Date: 25-Jan-2021
Our Ref: 2020/94403

**Non material amendment to previous permission 2015/92476 for erection of three
detached dwellings**

**Land at, Old Lane/Taylor Lane, Scapegoat Hill, Huddersfield, HD7 4ND
Application Number: 2020/94403**

Proposed Residential Development at :-
Scapegoat Hill, Golcar.
Plot 2 - Elevations
Sheet 1

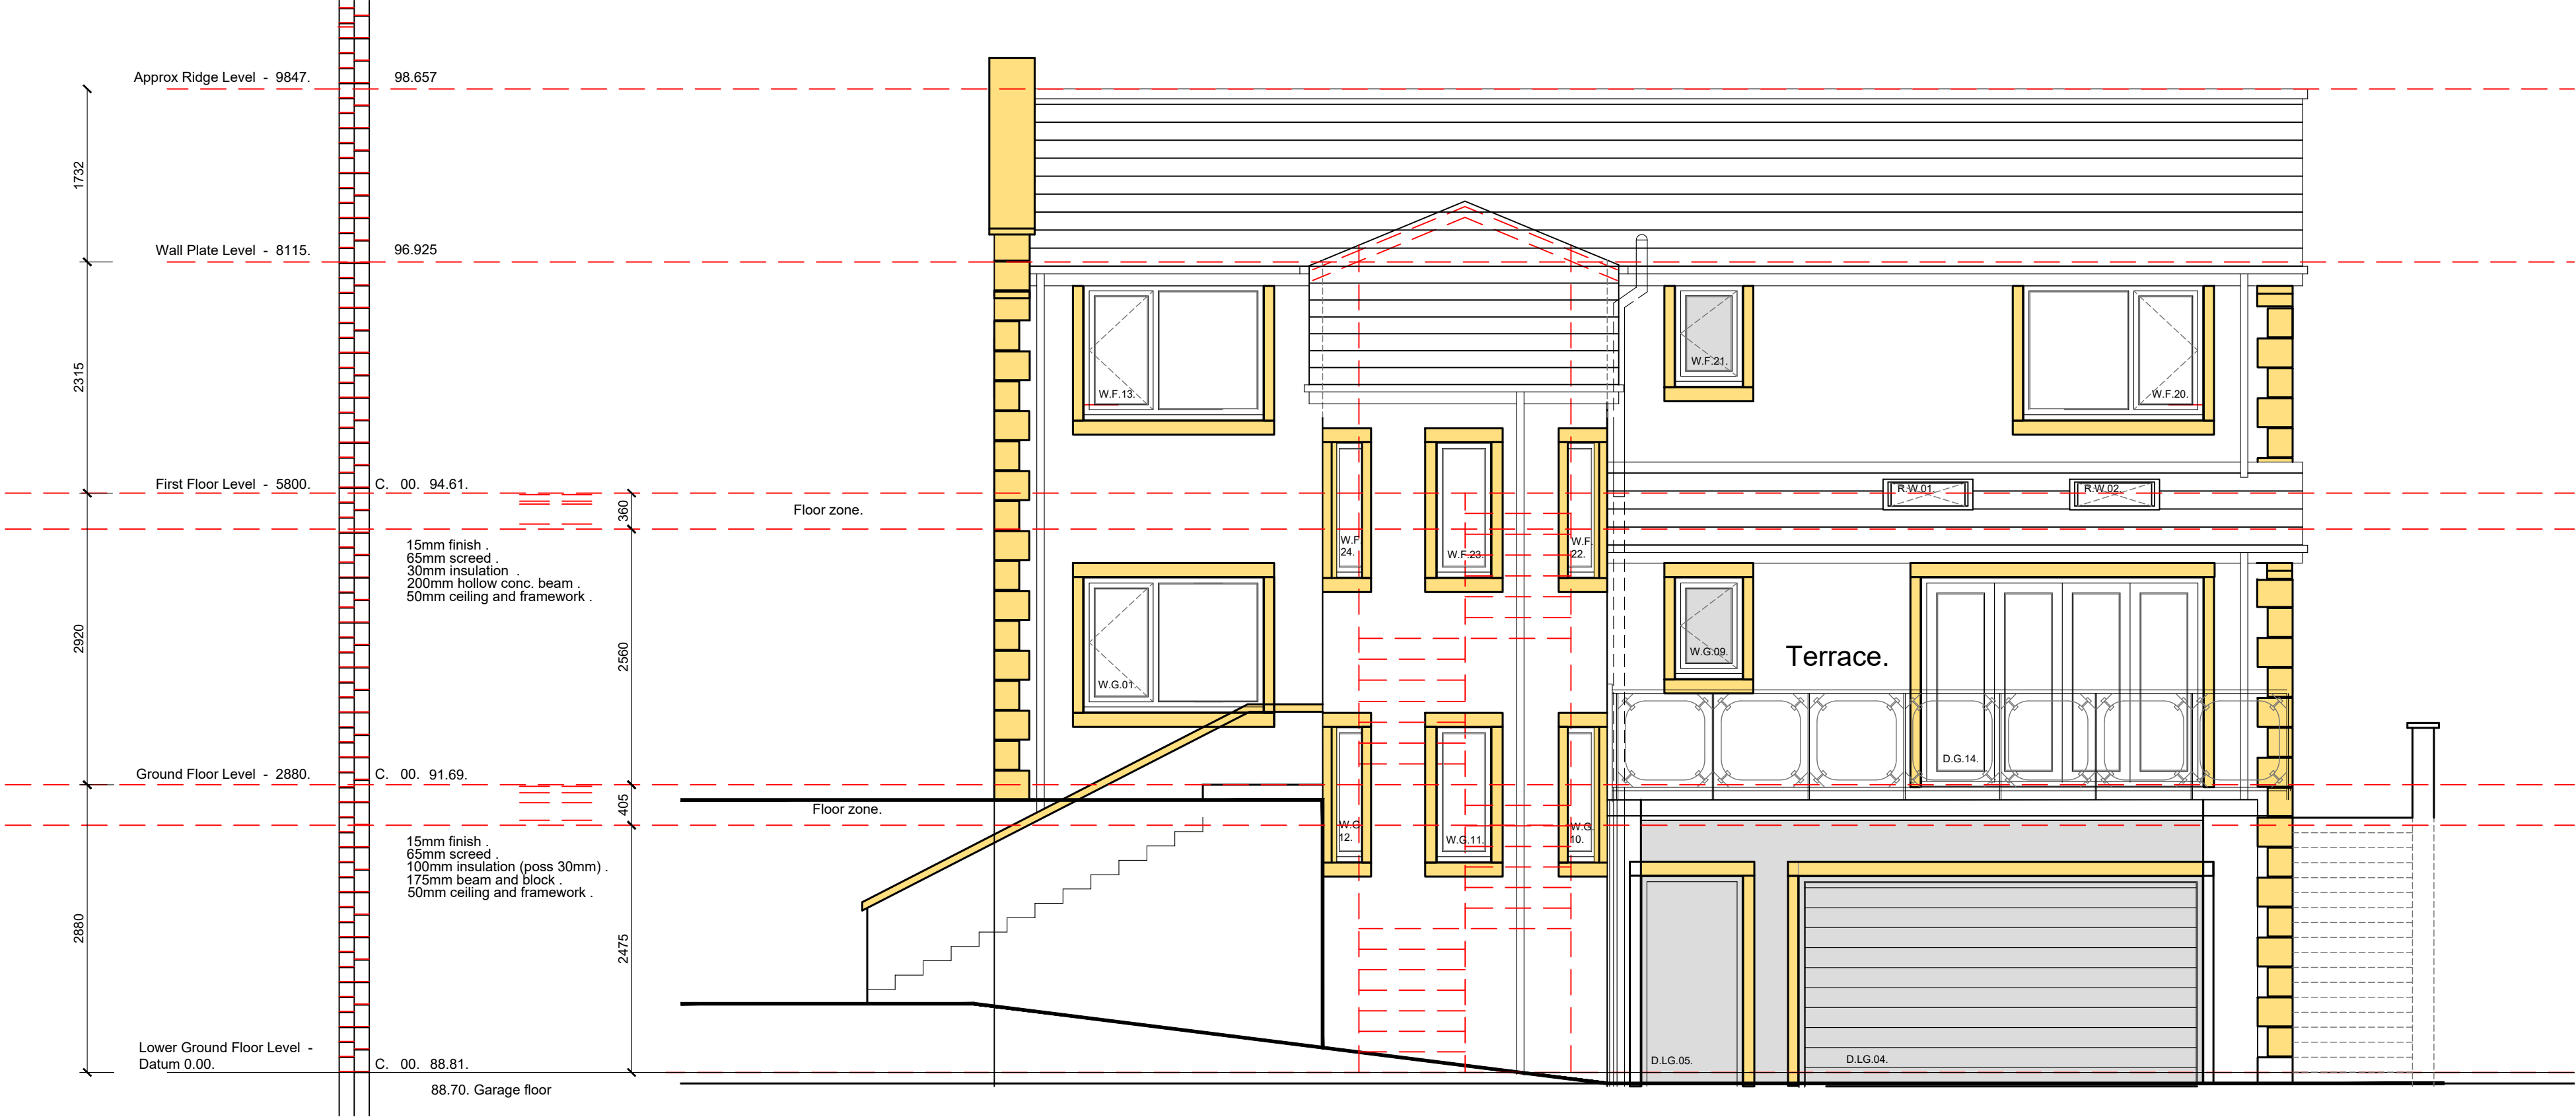
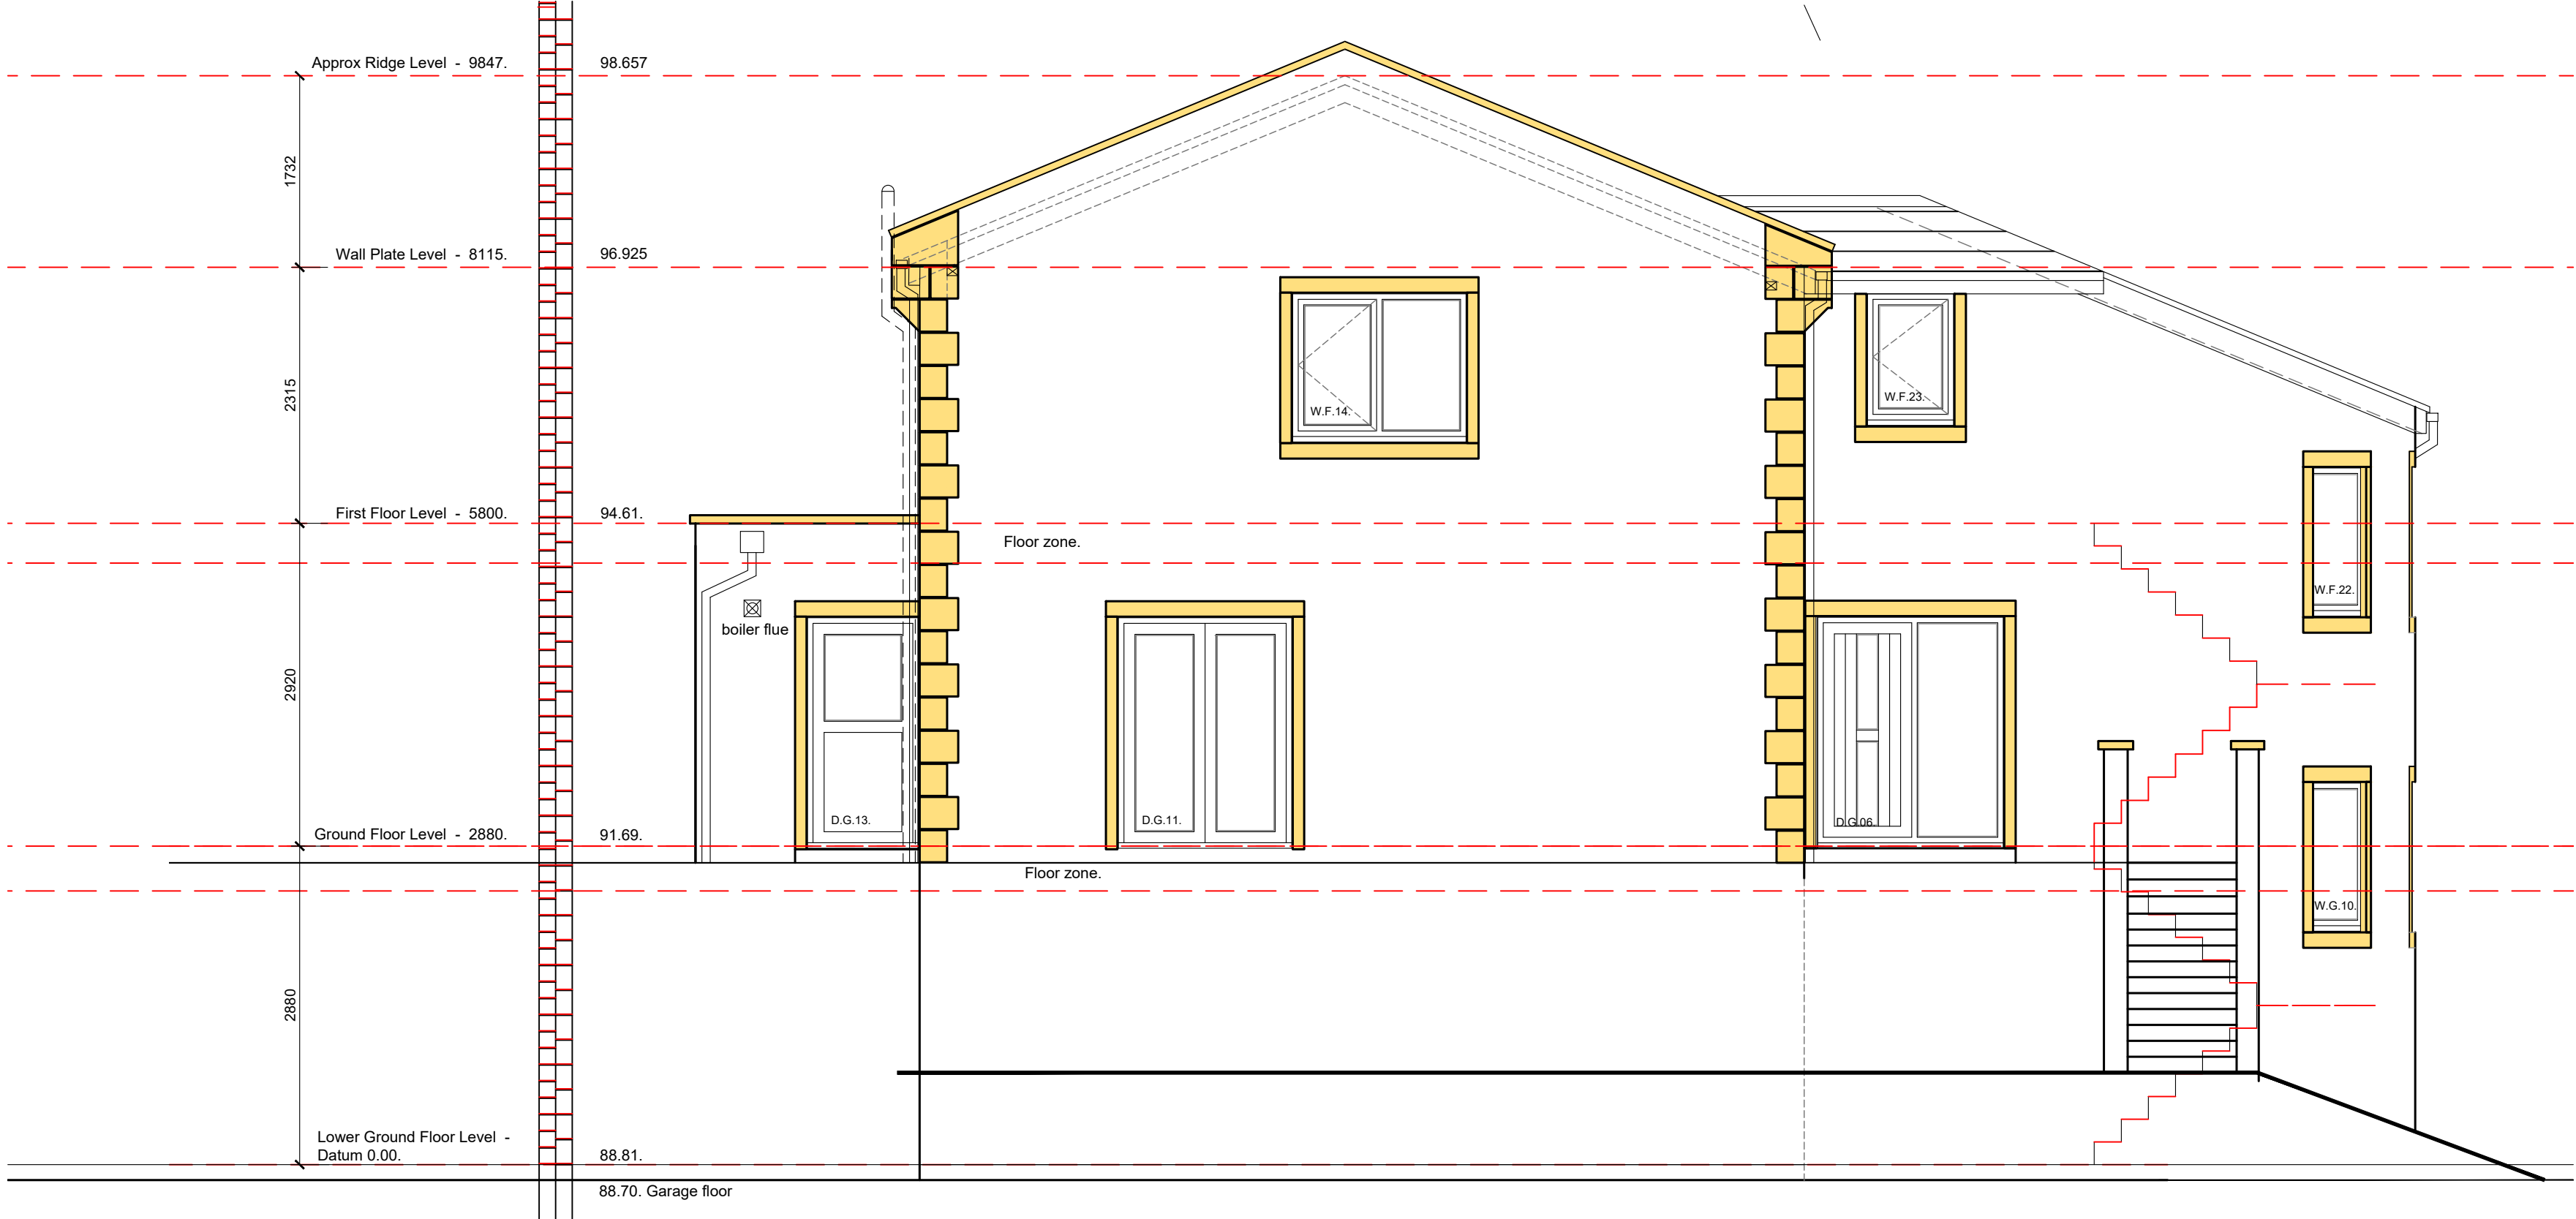
Having compared the approved plans under the 2015/92476 application to those in which have been submitted as part of this application, it appears that significant changes to the overall height, design and form of plot 2 are being proposed. This would result in a material and visual change to the scheme and therefore a new application would be required.
